***Changes to the design and operation of a
child care centre at 61 Mobbs Lane Epping
(MP08_0258 MOD 5)***

Director-General's
Environmental Assessment Report
Section 75W of the
Environmental Planning and Assessment Act 1979

July 2012

SITE & ROOF PLAN 1:500

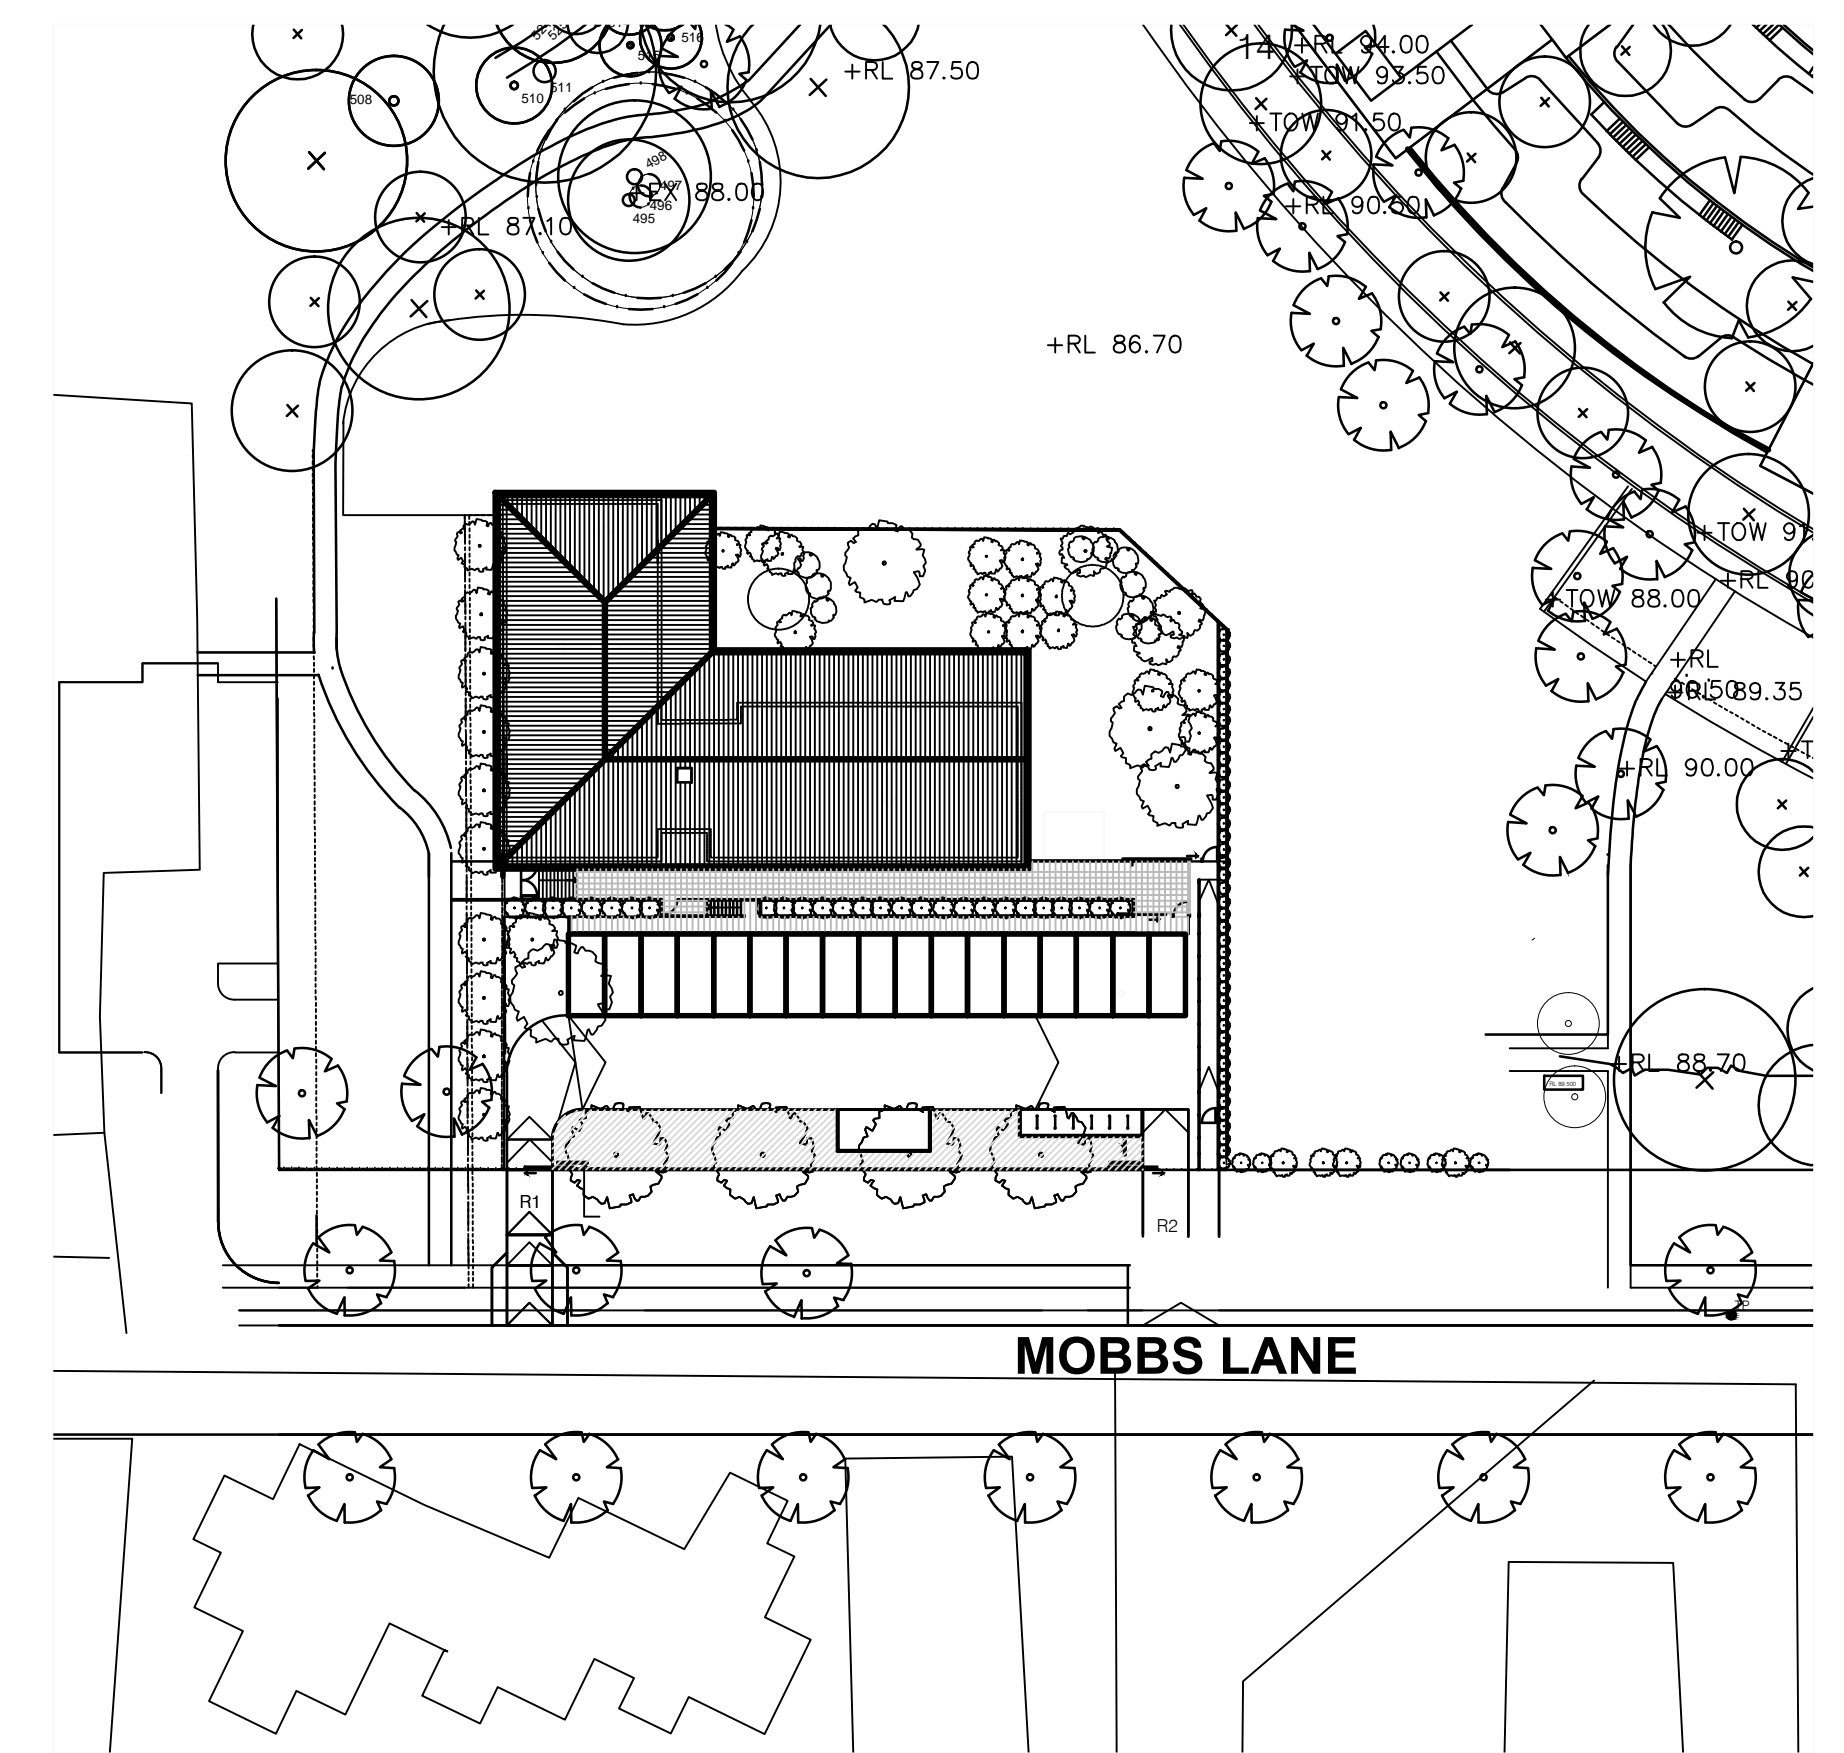
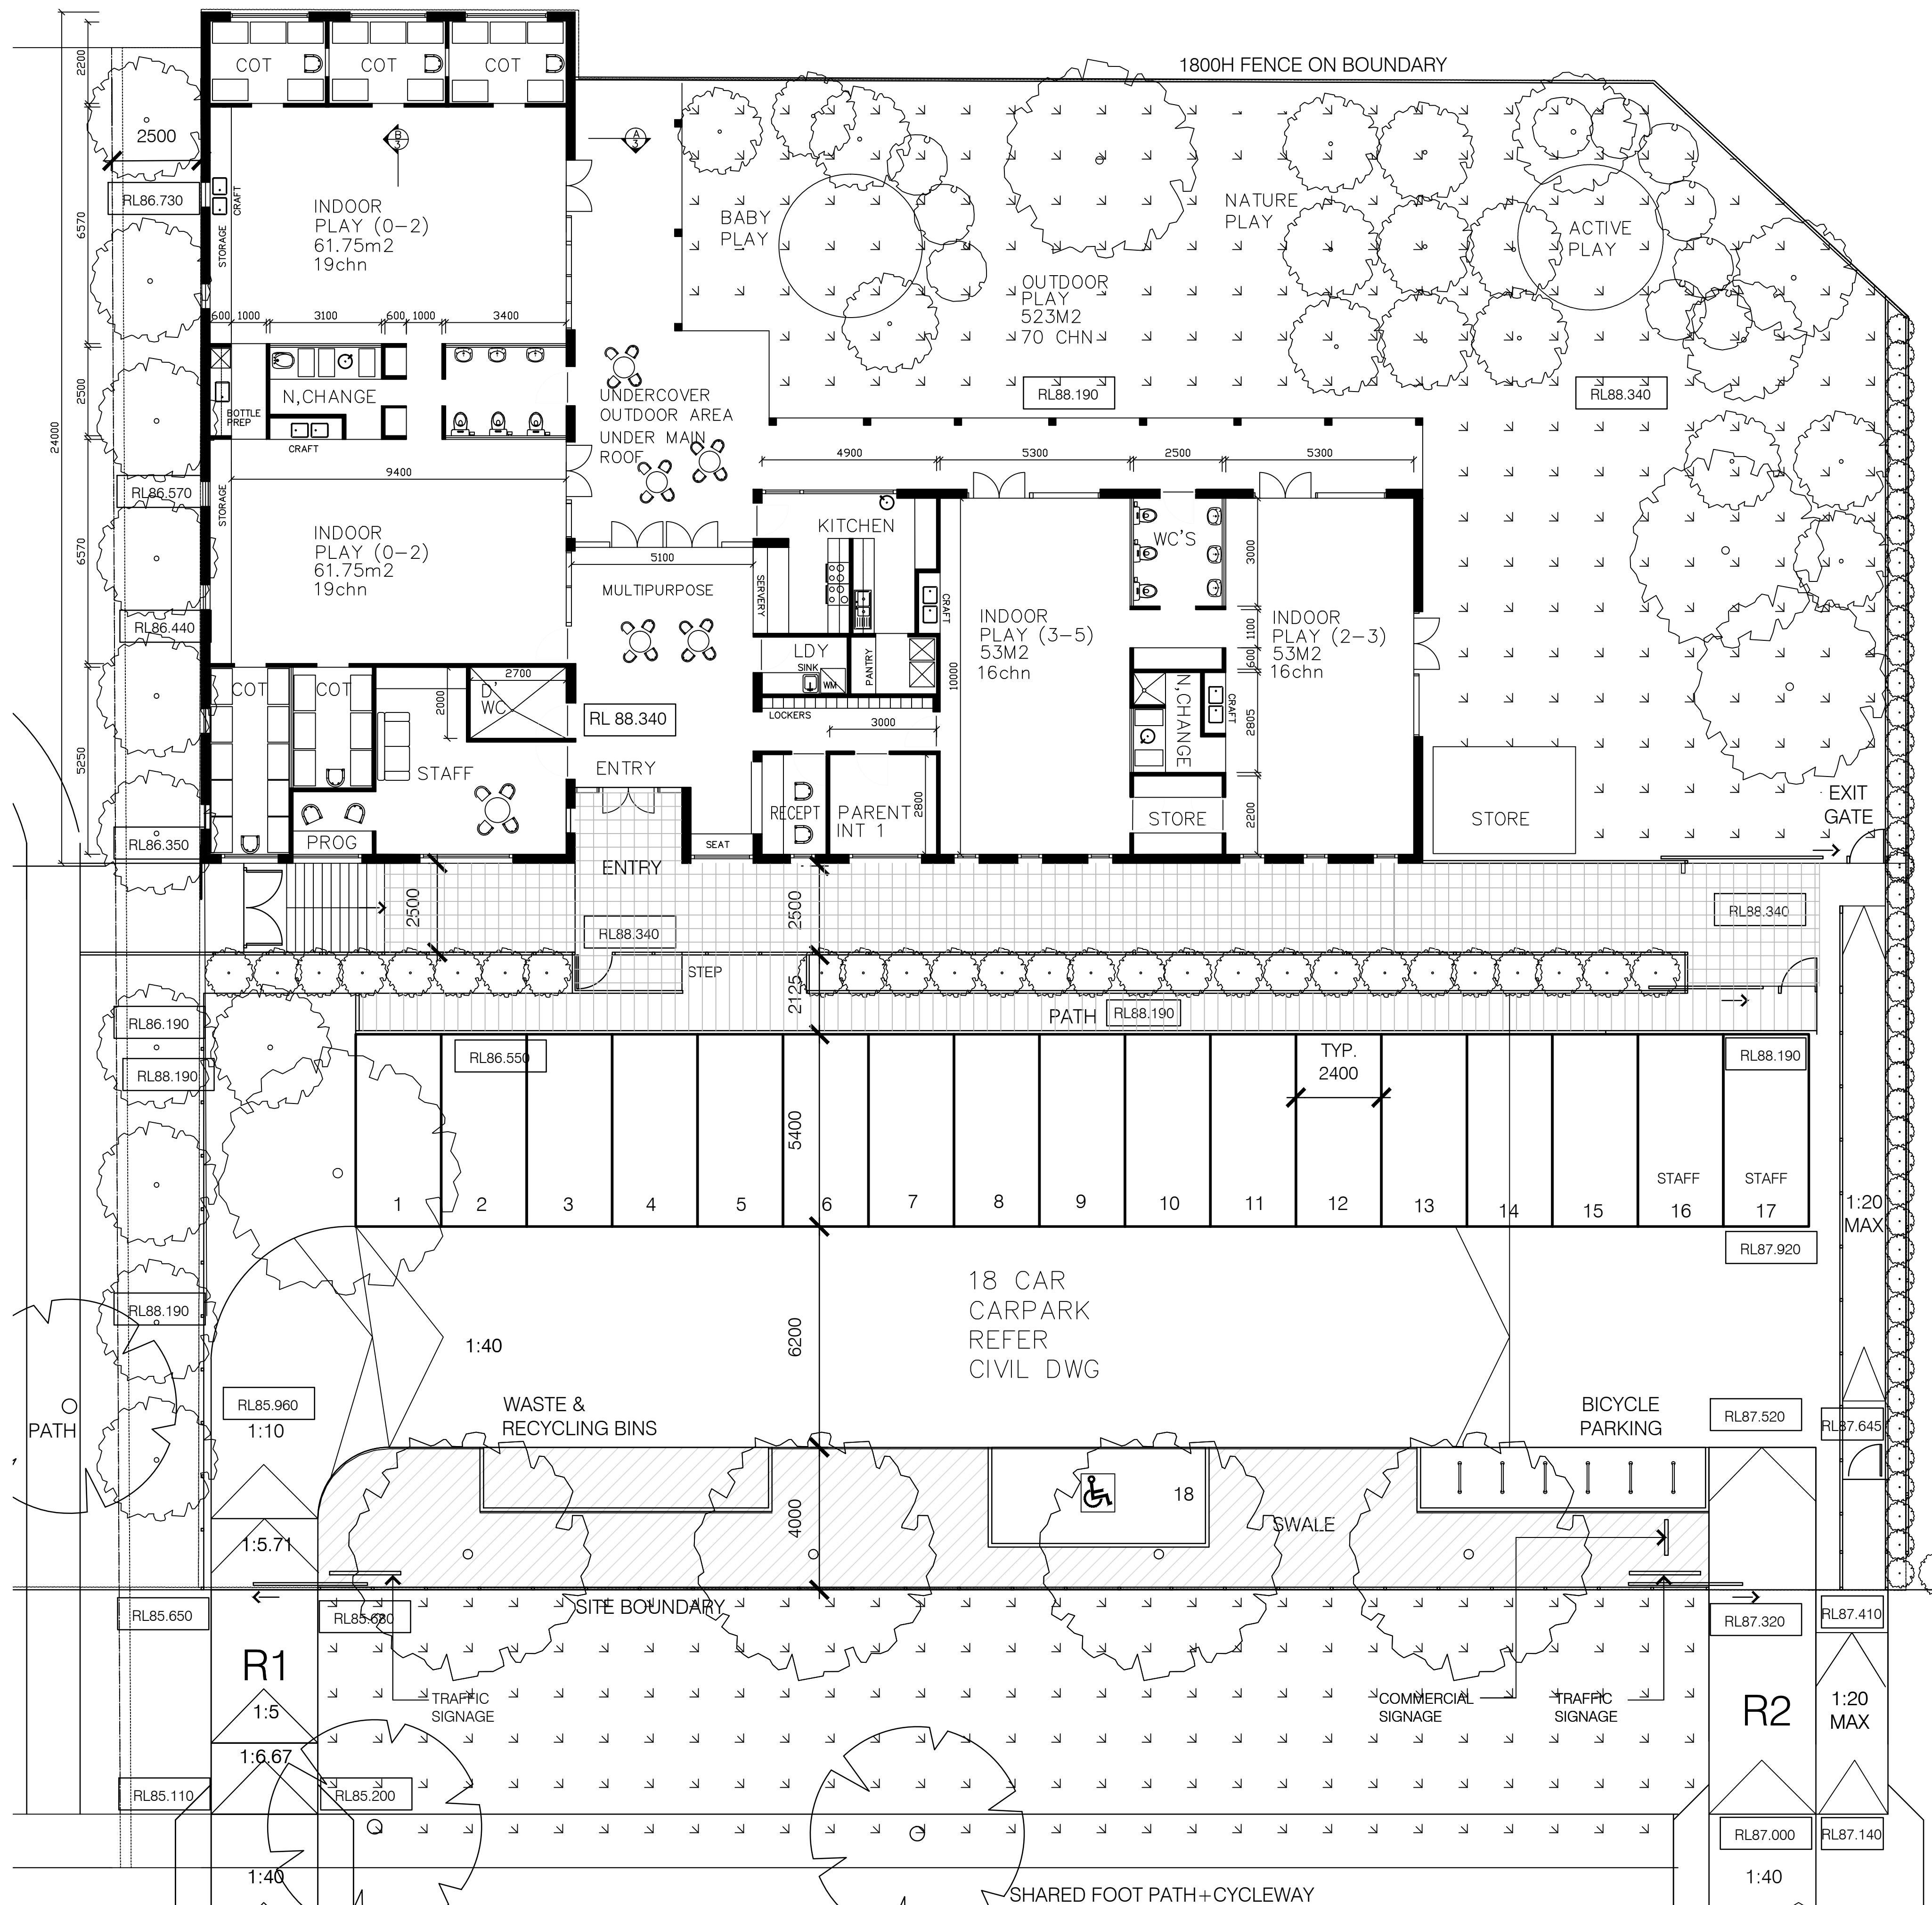
The number of car parking spaces complies with council's minimum requirements. The location of the disabled car space shall be designed in accordance with AS1428.1 and AS2890.6. Planting shall be incorporated within the front setback to reduce the visual impact of the car park area.

The location of the waste area will result in loss of landscaped area within the front setback and impact on the amenity and streetscape. Council requests that this waste area be relocated away from the front setback and be appropriately screened from public view.

The bin storage area has been relocated to the north-west corner of the car park area. Bins will be discreetly tucked away to reduce any visual impact on the street.

With regard to car parking, existing Conditions 'C22 Parking Spaces' and 'C23 Disabled Parking Spaces' ensure visitor, staff and disabled spaces comply with the Australian Standards. An additional condition is also recommended to be imposed which will require the establishment of landscaping along the front boundary to reduce the visual impact of the car park area.
